Your ref: SSD 5175 Mod 2
File no: MC-12-1769

Project: SSD 5175 Mod 2 Eastern Creek Business Hub s96(2) modification request to amend the indicative concept plan, urban design guidelines and permitted uses

Re: Council comments for the further Response to Submissions

Figure 2 – Location of the proposed loading dock

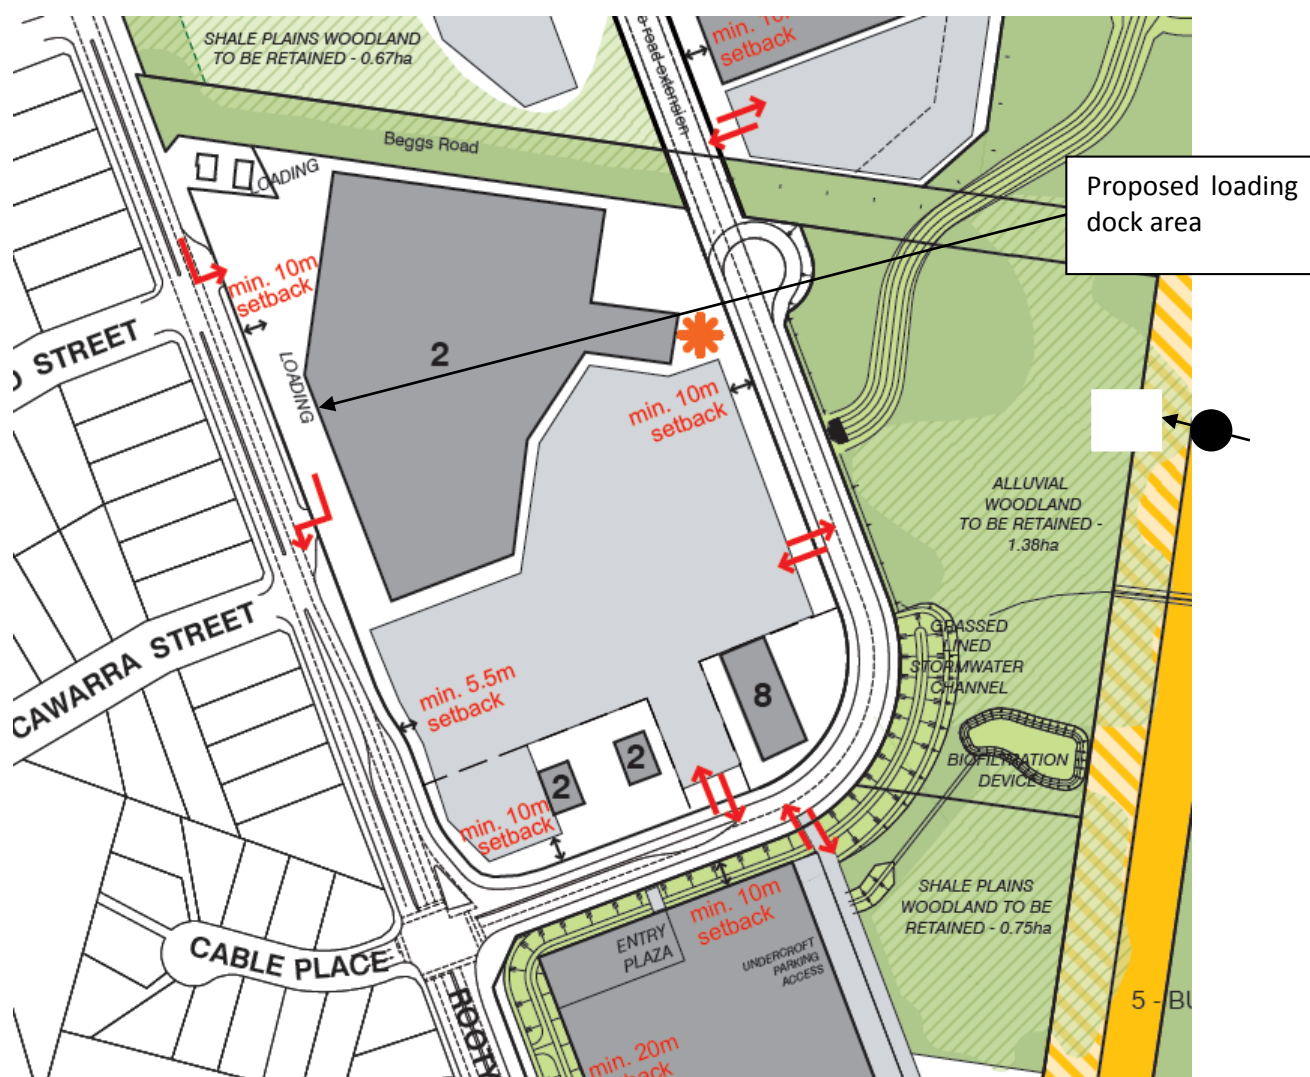
The Response to Submissions is accompanied by an Acoustic Assessment which states only that the Lot 2 loading dock will comply with the relevant noise level criteria. The Submission also states that a 2.1m acoustic wall will attenuate the acoustic impacts of the Lot 2 loading bay and achieve the sleep disturbance criteria.

We are unable to undertake an assessment of this statement in the absence of a full acoustic assessment, which the Applicant states will be provided for the future detailed Development Application. In particular the effectiveness of the acoustic wall given its distance from the loading dock. We do not consider that the conceptual acoustic mitigation measures will be sufficient.

Figure 53 52: Development Control Plan - Lot 2 (not to scale)

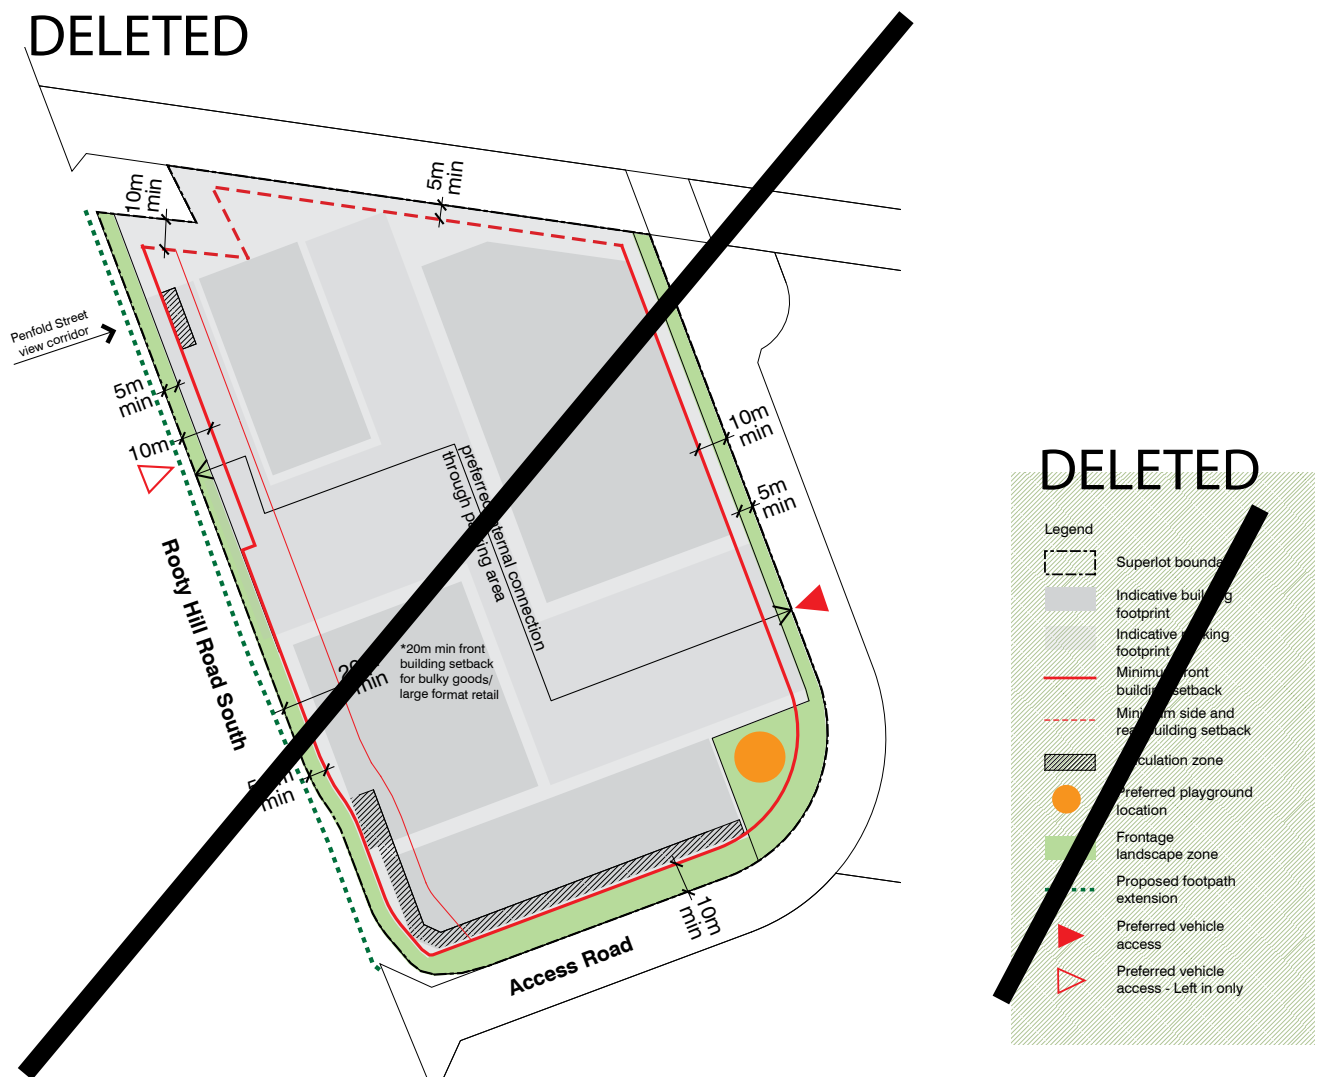
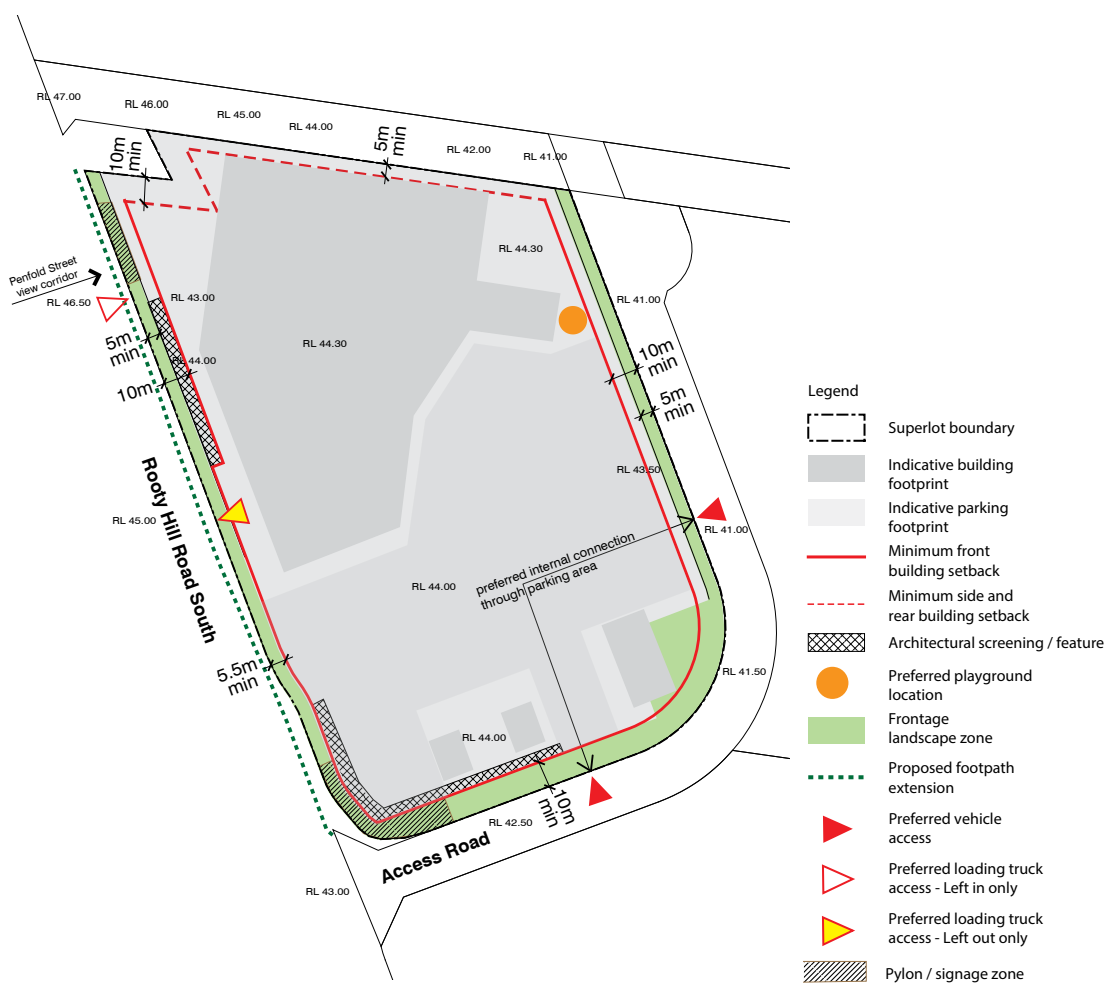
Planning Matters
The reorientation of the Lot 2 loading areas results in potential amenity impacts on the two adjoining residential properties to the north-west of the subject site. The proposal should be supported by a detailed plan of management for the loading areas and Beggs Road including mitigation measures to be implemented and improved as required.
Drainage and Engineering
Condition B12 Contamination is required to be amended to reflect the following requirements: Future development applications for the construction of buildings shall include a stormwater management plan in accordance with the Water Cycle Management Strategy Report Incorporating Water Sensitive Urban Design Techniques prepared by J. Wyndham Prince dated March 2013 and Council's Engineering Guide for Development 2005 and part J of DCP 2015. The Stormwater Management Plan is to include a requirement that 80% of non-potable demand be met through an alternate water source. Where this 80% cannot be achieved through roof rainwater alone the treated underdrain flow from the bioretention system is to be used for landscape watering and/or other uses subject to appropriate treatment.
